Planning Application No: 3/2021/0078

[REDACTED]. The rear of our house in Laneside Close is facing directly into some of the rear gardens in Beech Drive. In our case our property looks towards the garden of number 28 Beech Drive.

DRAWING TITLE / No.
PROPOSED DRAWINGS: PLANS & ELEVATIONS - 002

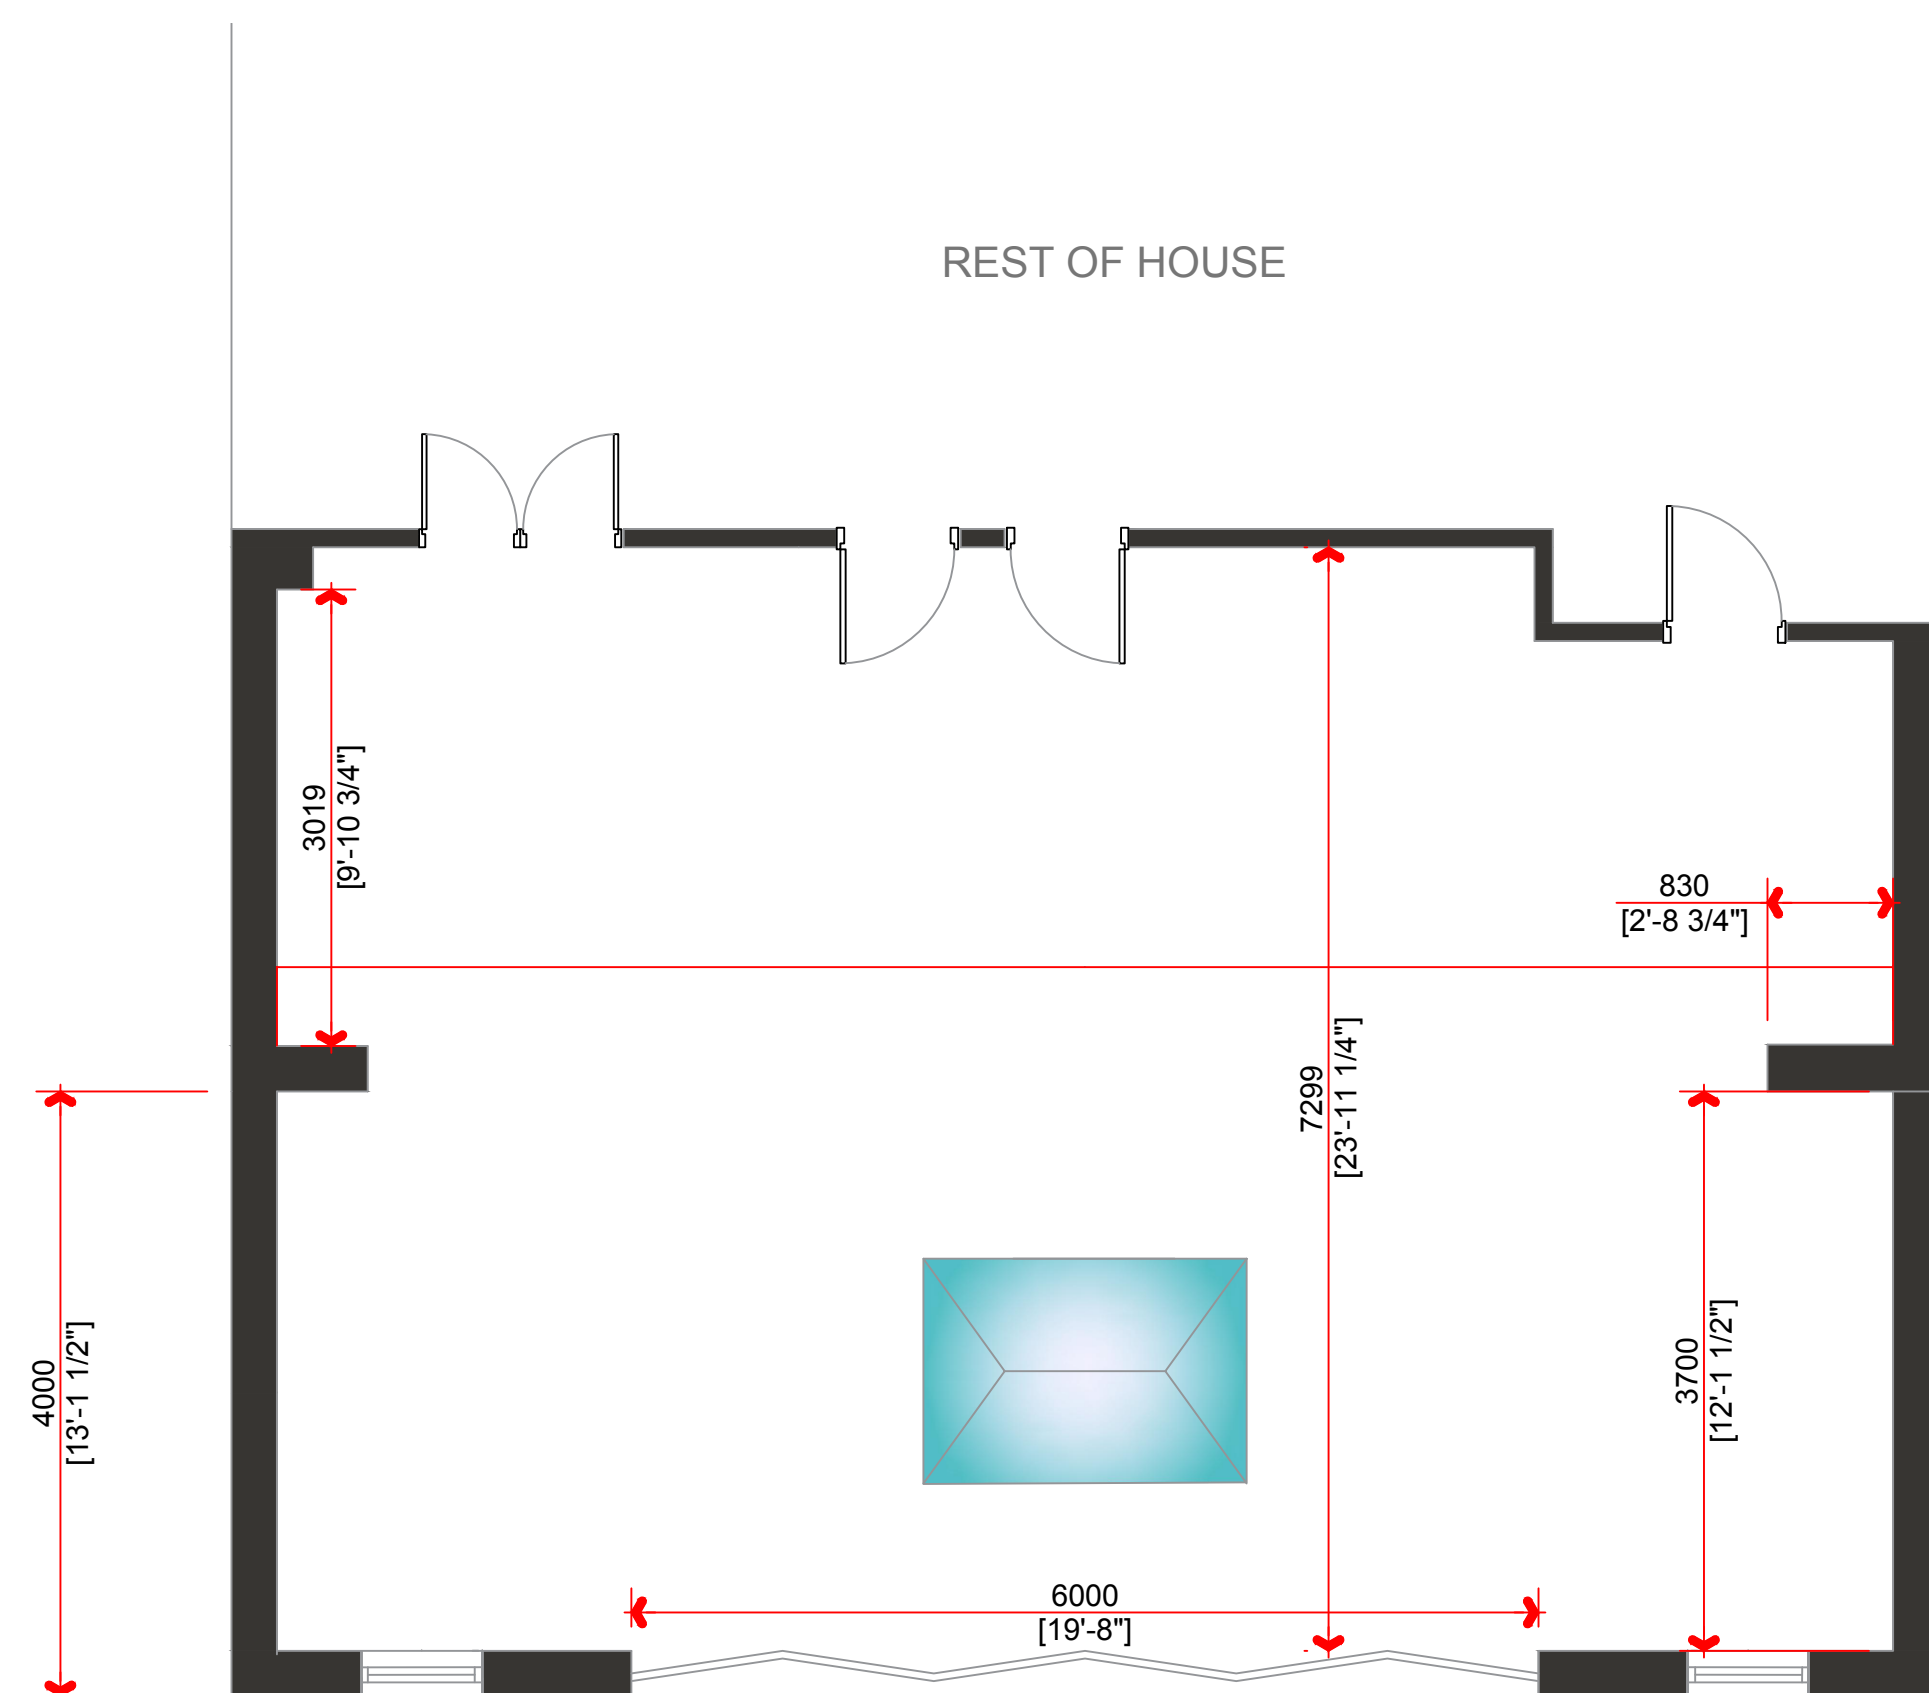
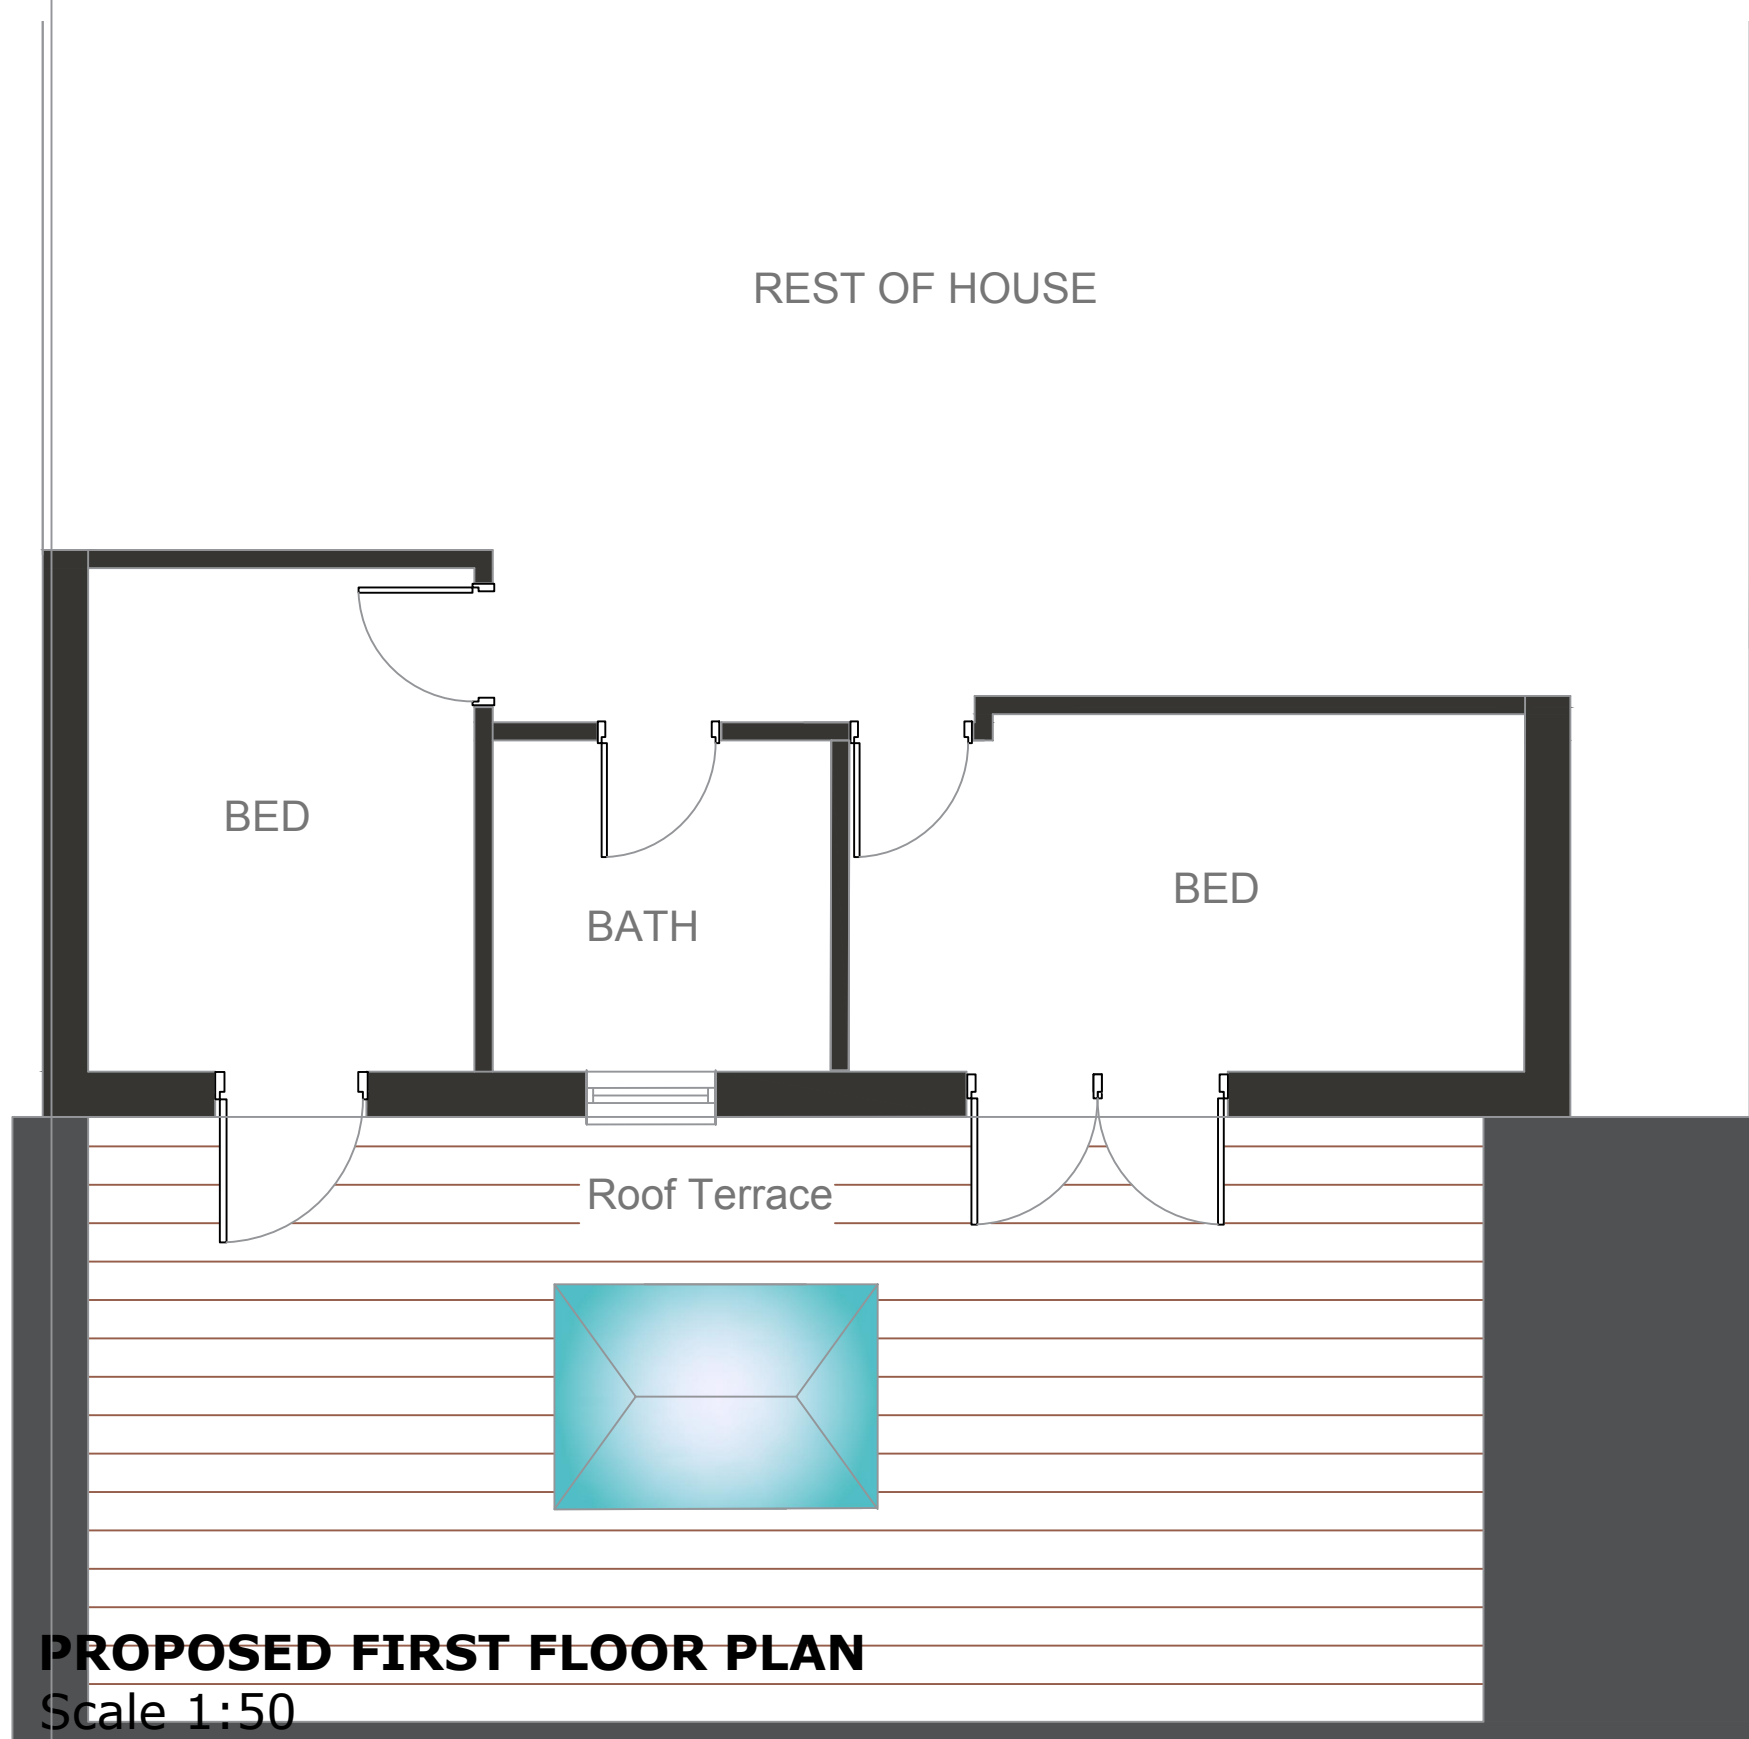
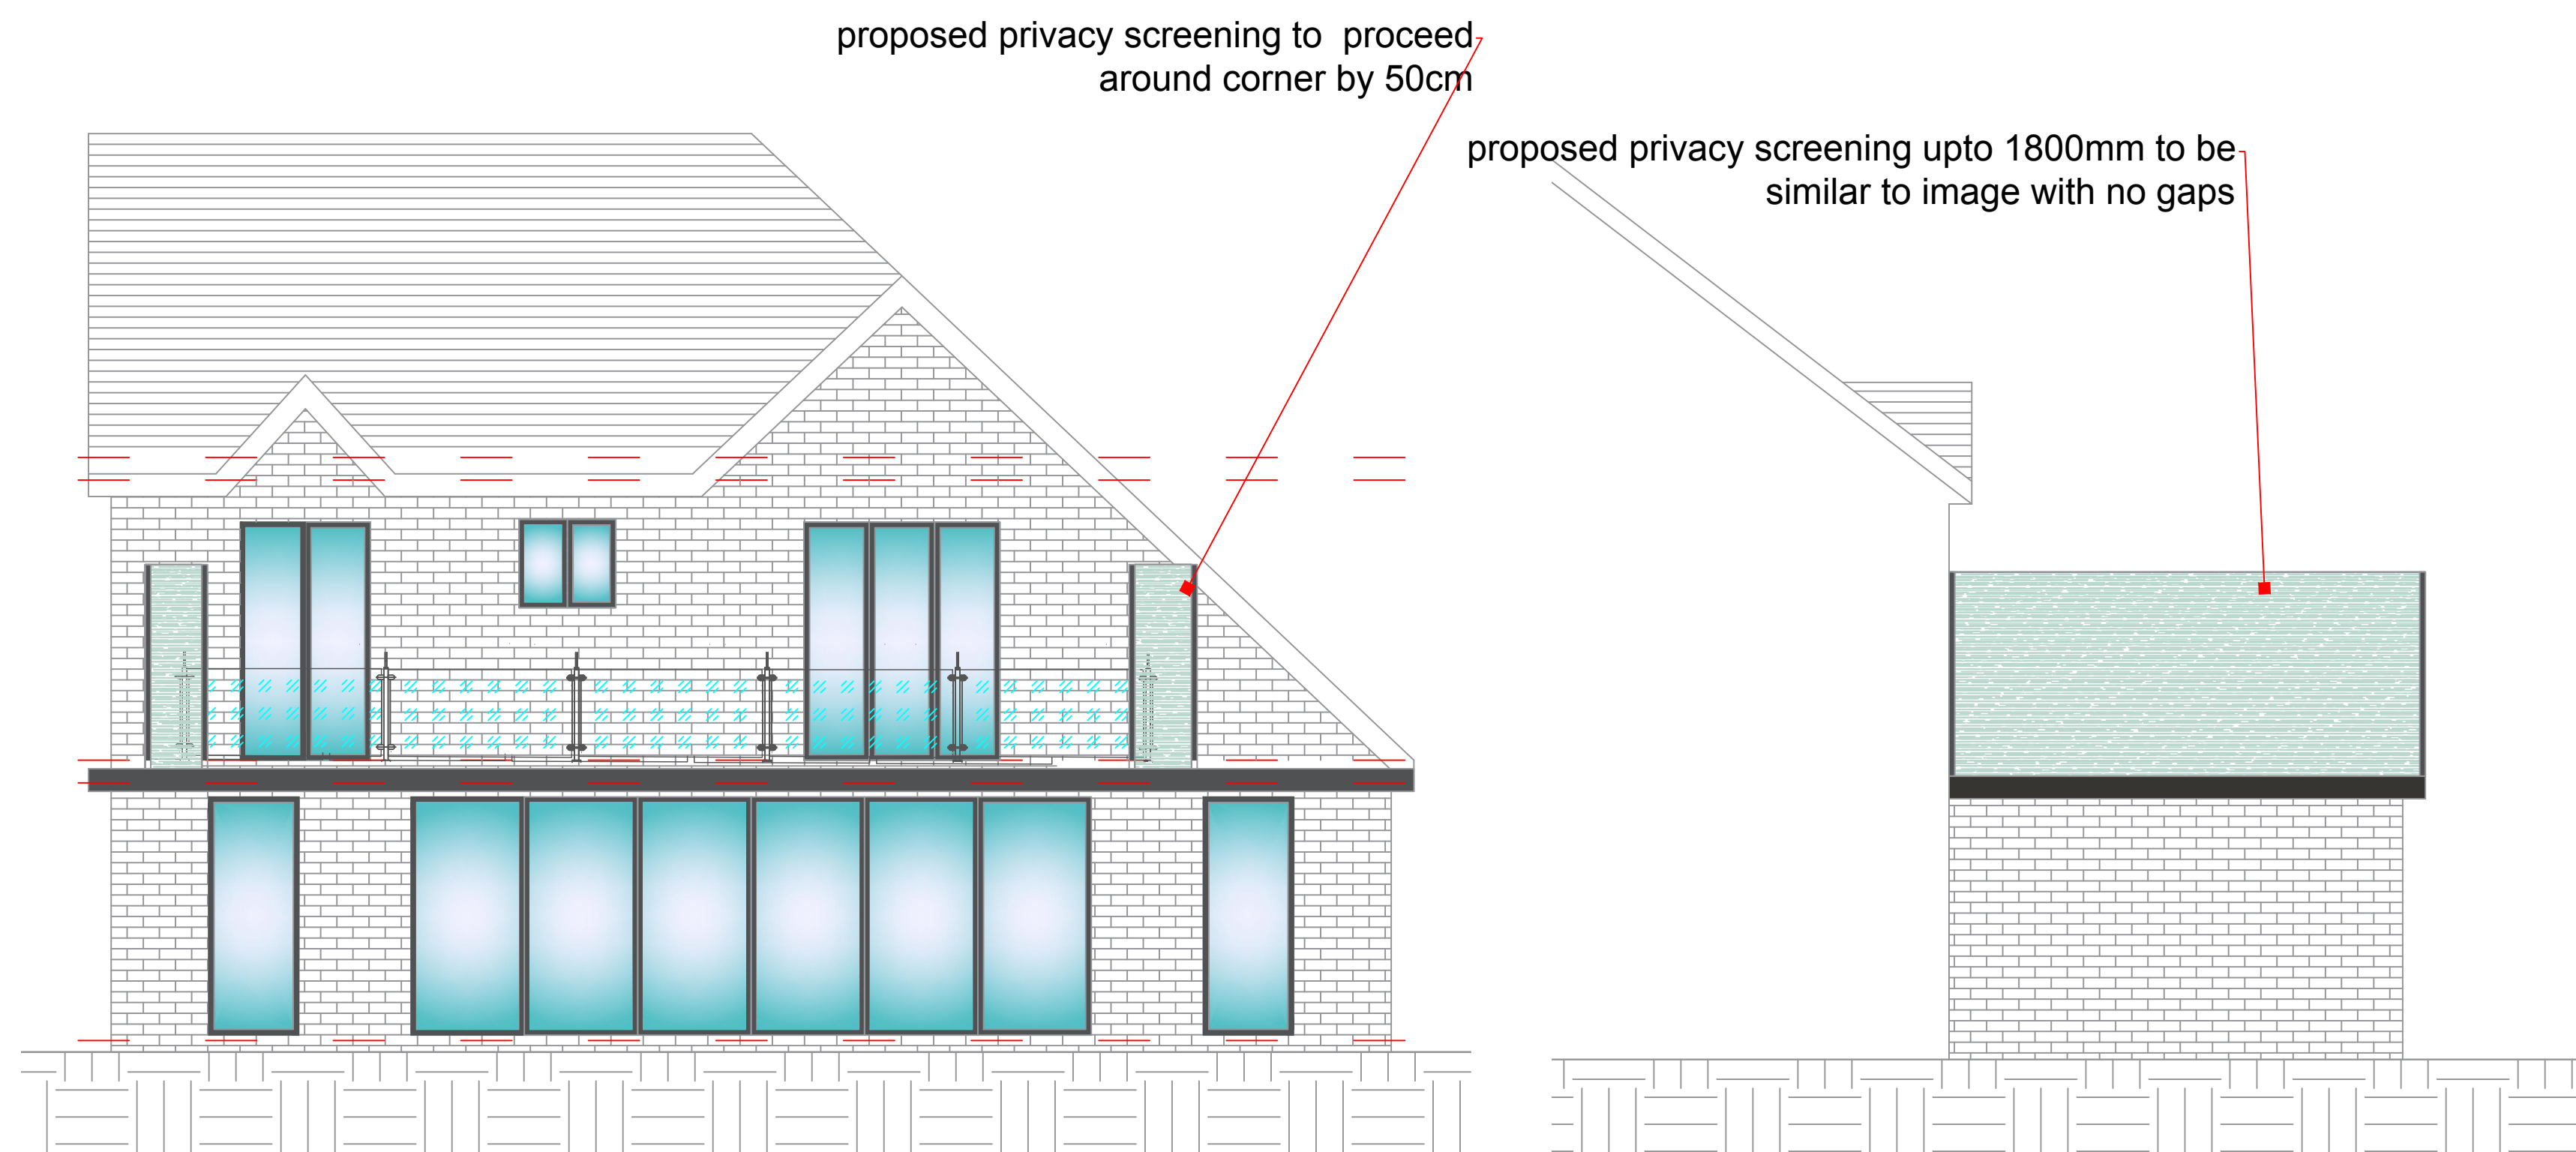
The planned roof terrace on the first floor would allow the residents of 28 Beech Drive to overlook our whole garden from the front of their terrace. We would feel a massive loss of privacy due to this.

At present we have an open view out of our windows at the back of the house and from our garden area. If the application goes ahead and they would build a brick wall with an additional roof terrace it would strongly influence our existing view, specially from the living room, in a negative way.

After reviewing the plans, the extension is grossly oversized compared to all other extensions on the estate. Not only it is the full width of the back of their house, but also two floors which includes the roof top terrace. An extension of this size would be out of proportion with other extensions on the estate and extremely overbearing to us and the other neighbours.
